RE: EPC Comments – BLR Village C Rezone (ZONE-25-0020)

On behalf of Clayton Properties Group II, A Colorado Corporation DBA Oakwood Homes, we respectfully submit the following responses to the review comments dated July 09, 2025.

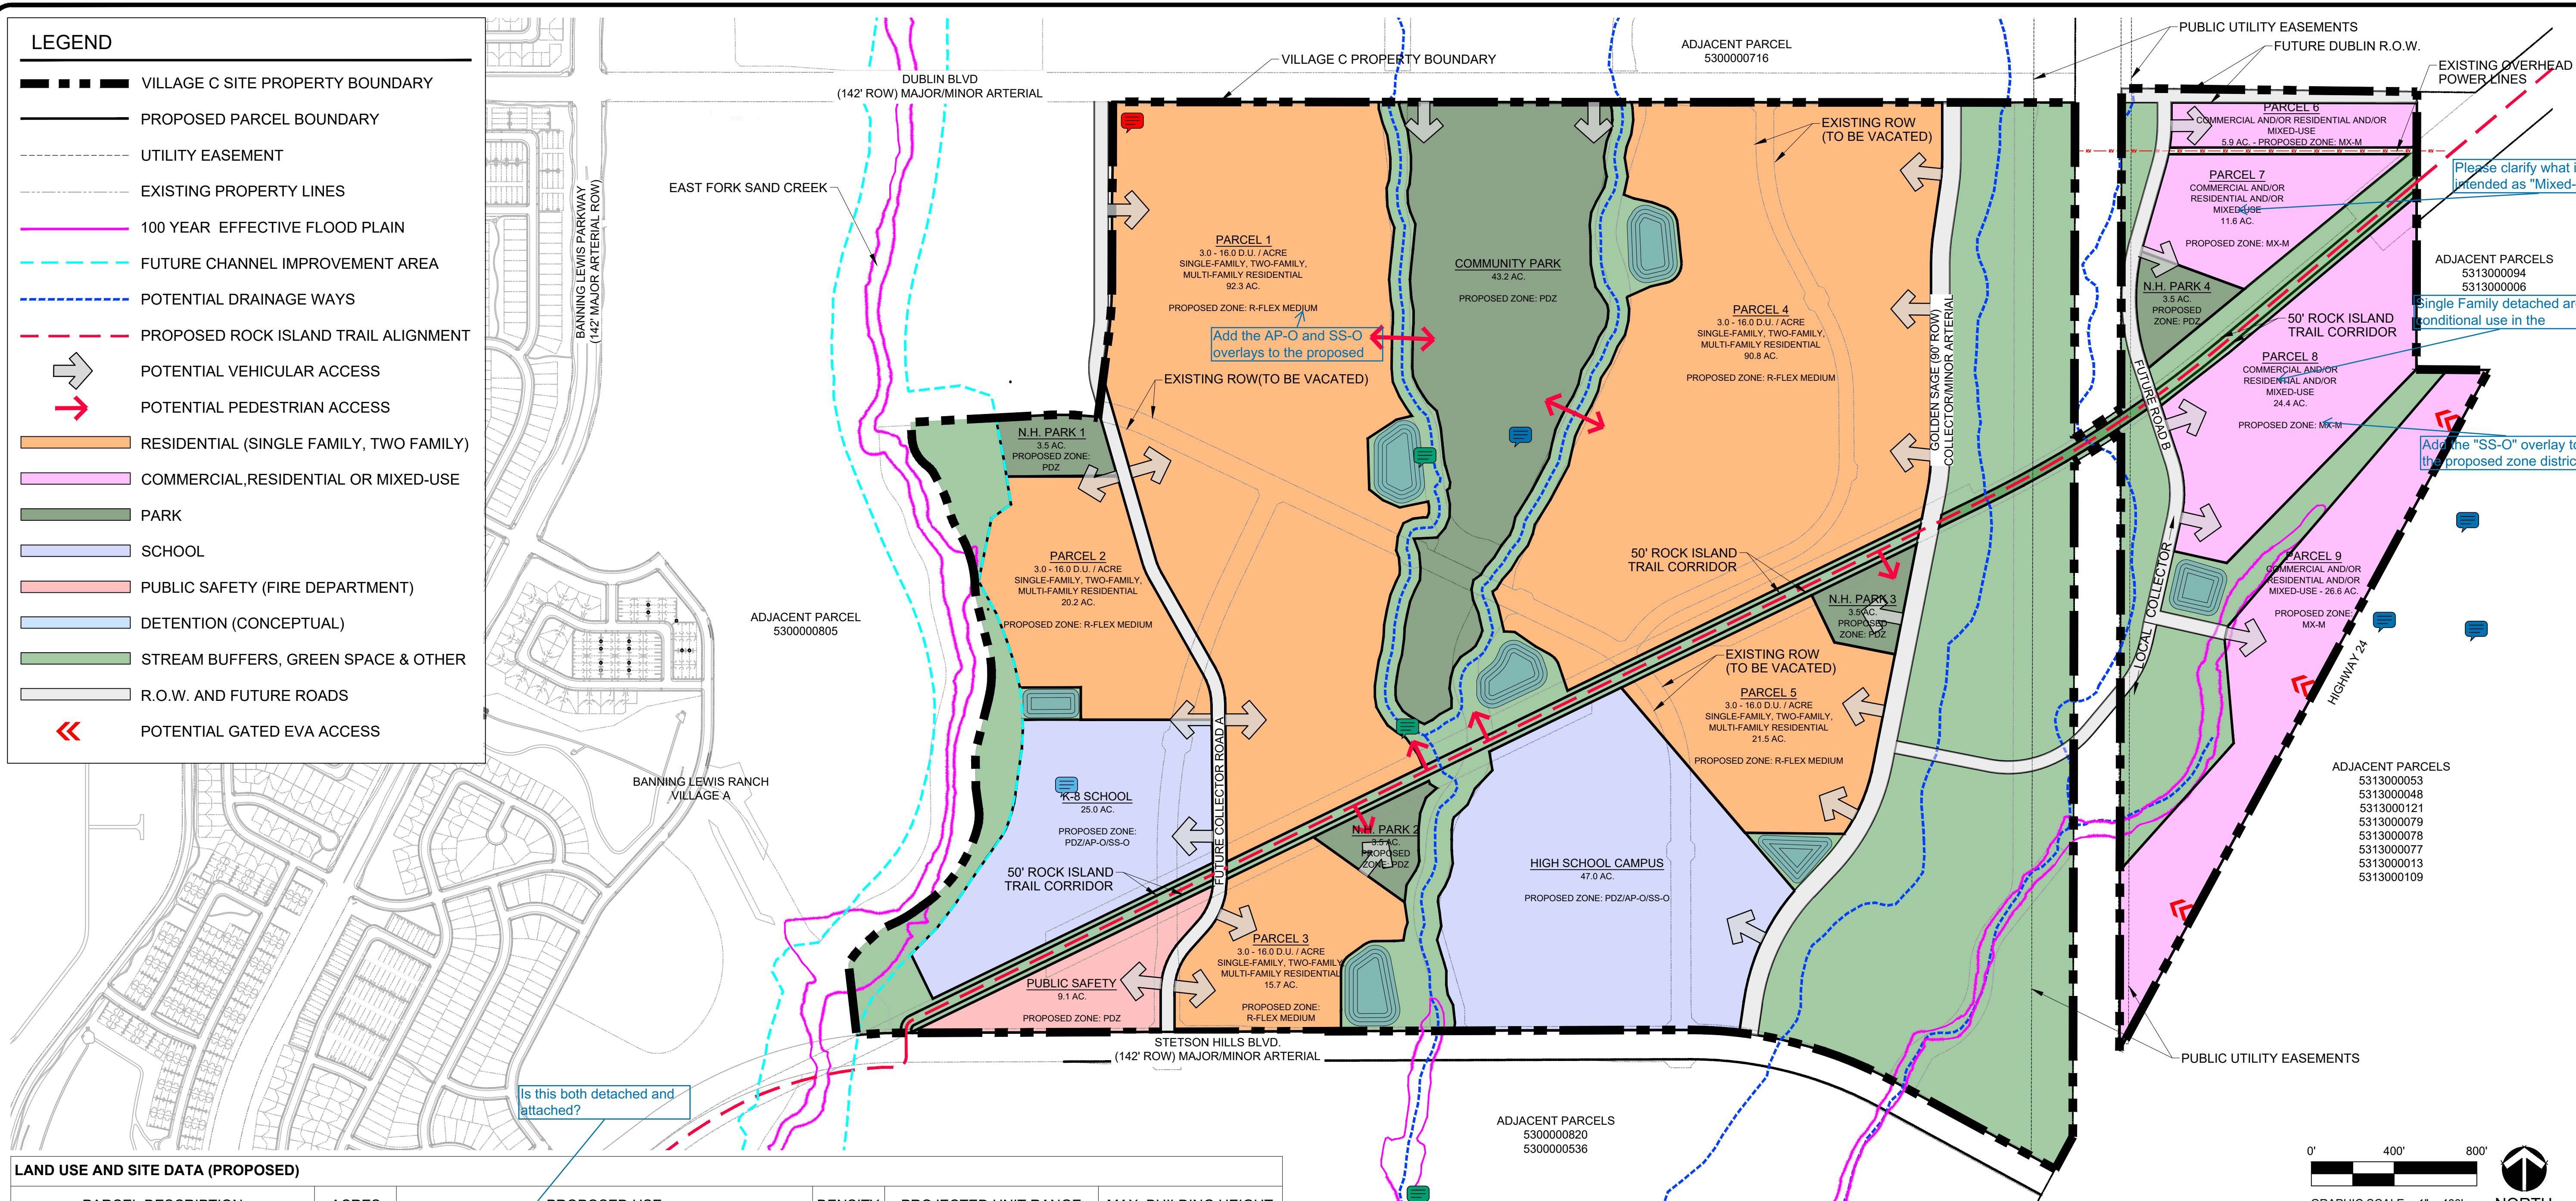
2. Is future access (secondary) for the Falcon Meadow Campground parcels being accommodated?
(Reference US HWY 24 Access Control Plan)

Response: No access to the campground has been requested, current direction is they will have their own access off Highway 24. CDOT has mentioned being accommodatable to emergency gated access from highway 24 as well. Land Use plan only shows major roadways.

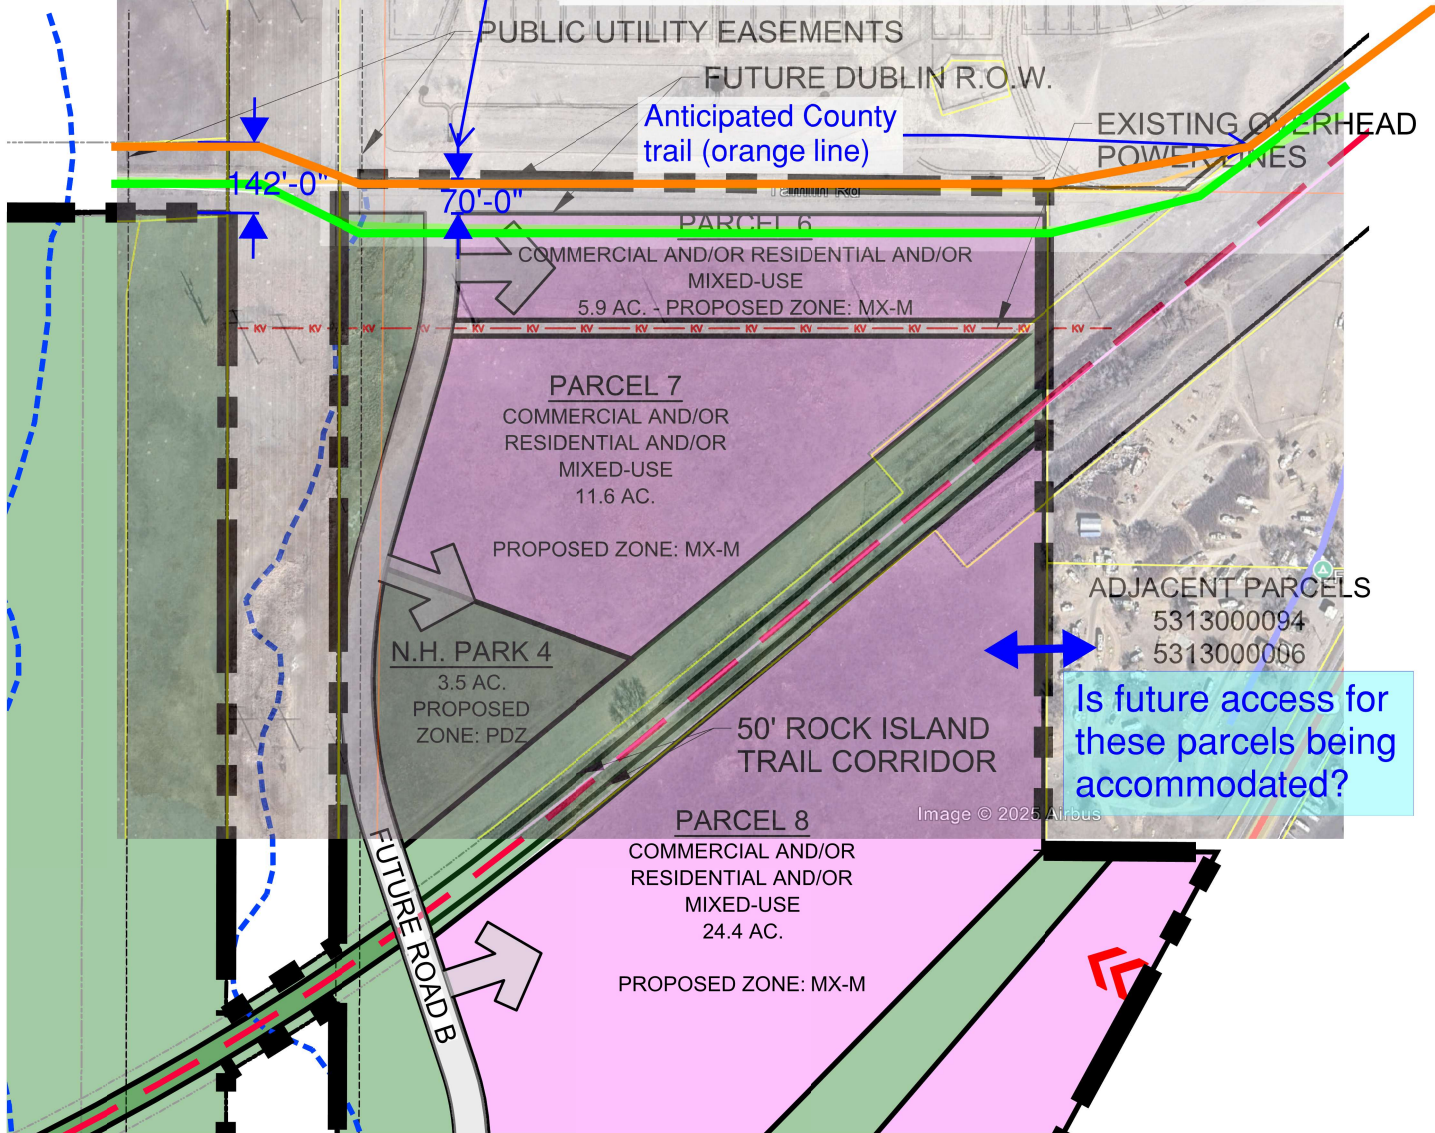
1. Note: Coordination is needed between the developer, the City and EPC (DPW and Parks) regarding the Dublin Blvd./Falcon Highway alignment. See attached sketch/redlines.

[Response: Coordination is on going. Current direction per meeting on 9/8/2025 with Jeff Rice, Todd Frisbie and development team is that BLR Village will dedicate at a future plat 70' to the ROW of a future Dublin ROW with a 5' easement and an additional 30' will need to be provided from adjacent land owner or through city annexation or another method for 100' Minor Arterial through this area.](#)
